# HIGH MESA Consulting Group

2017.014.2  
September 26, 2017

RE: Letter Explaining How EPC Conditions Have Been Addressed – Project # 1005237  
Request for Final Sign-Off for EPC Approved SDP for Building Permit and SDP for  
Subdivision.  
Tracts A-1, Mark 3S Holly Development

C2 MONUMENT SIGN
 PLAN AND ELEVATION 1/4" = 1'-0"

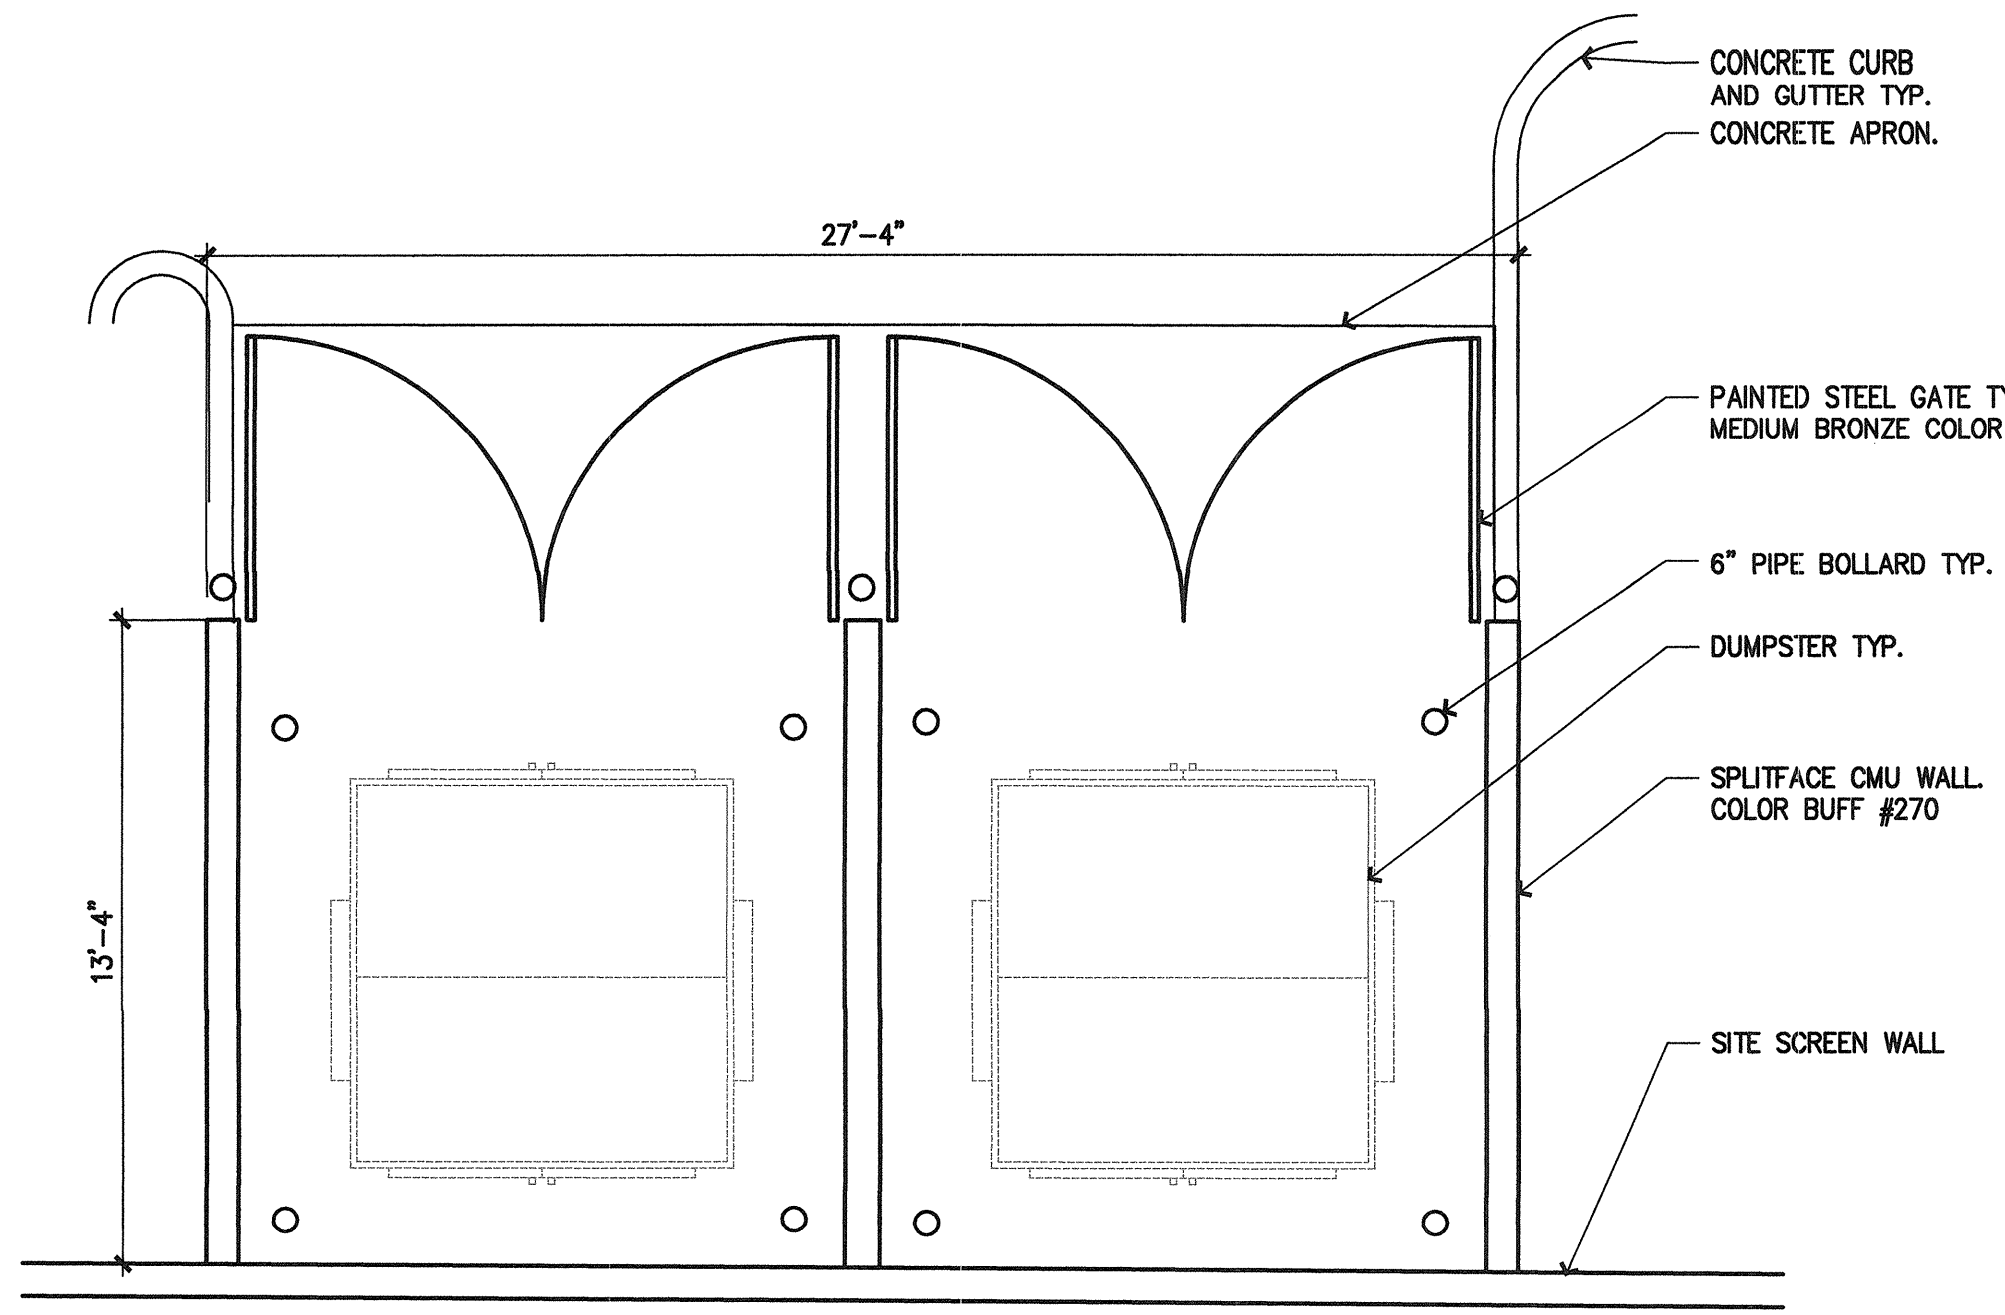
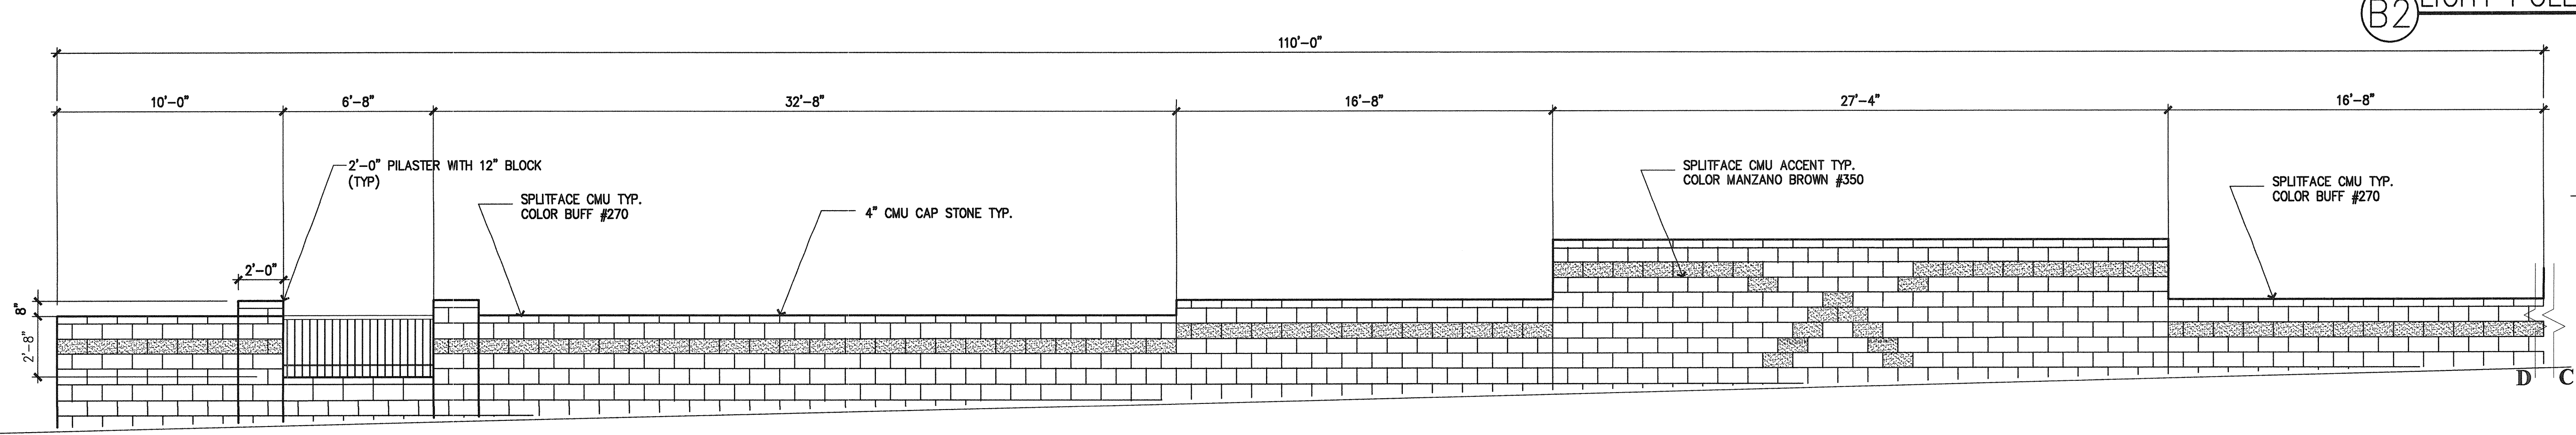
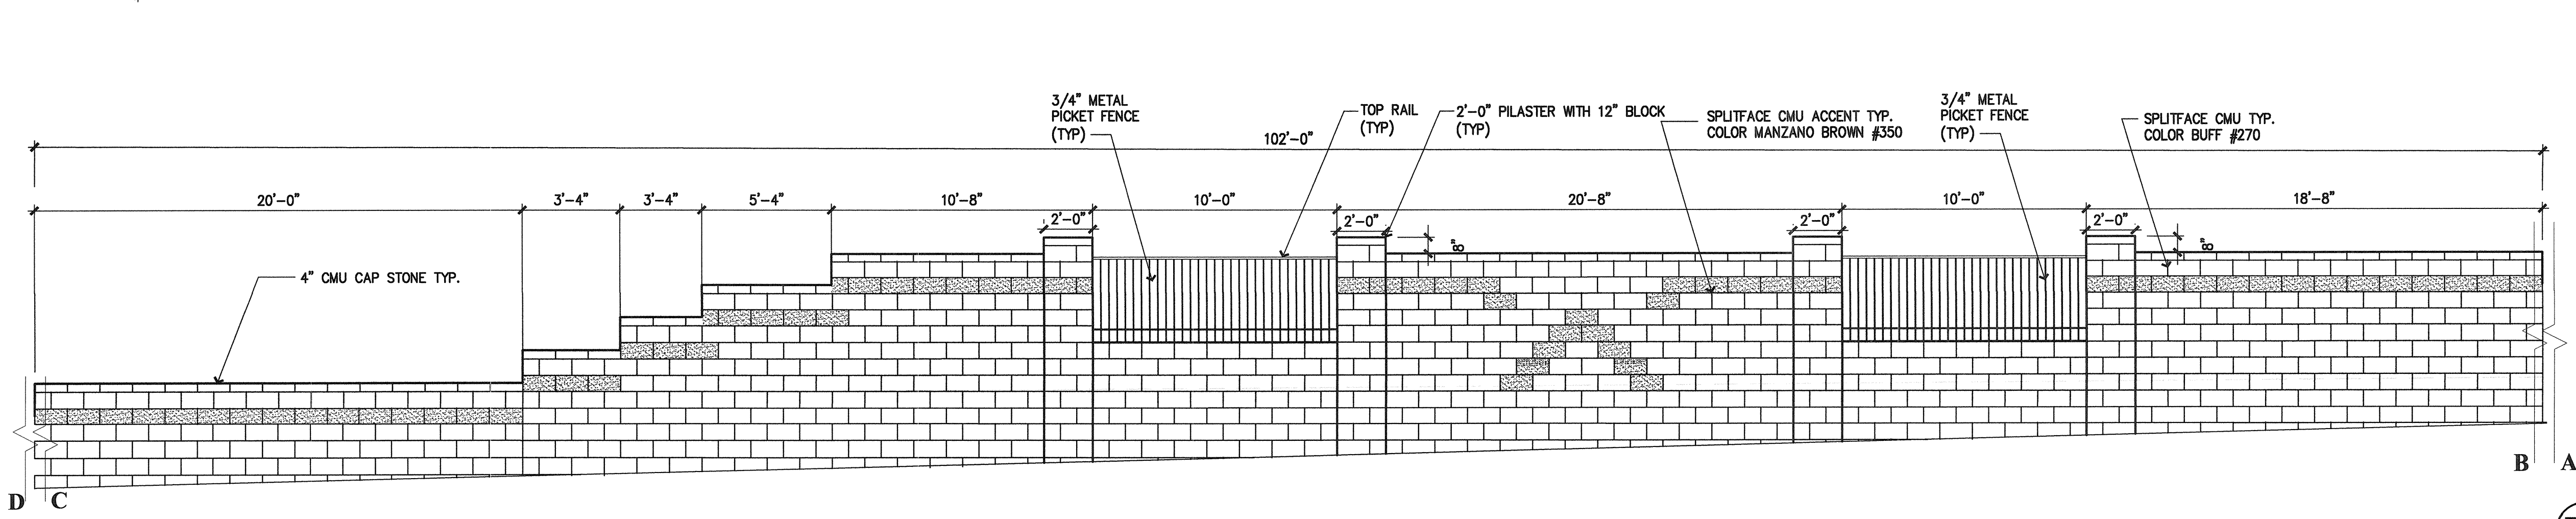
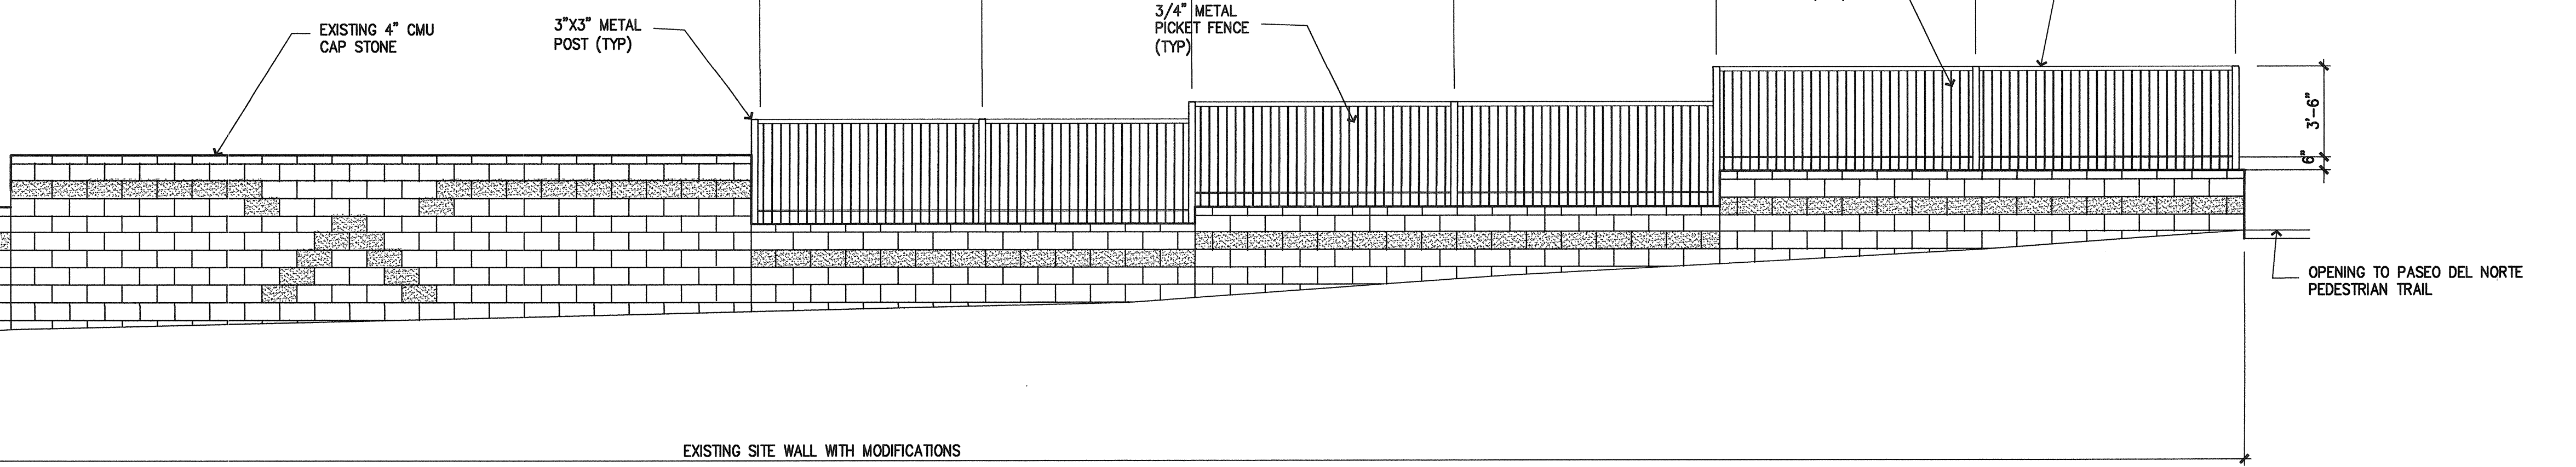
10) Walls: A decorative feature shall be added to the proposed wall pursuant to Zoning Code 14-16-3-19(C) (2) (a) (b). -*Pilasters were added to the proposed wall.*

- B. The refuse enclosure shall be labeled. *-Refuse enclosure is now labeled.*
  - C. The amendments shall be listed. *-Amendments are listed on Sheet 1.*
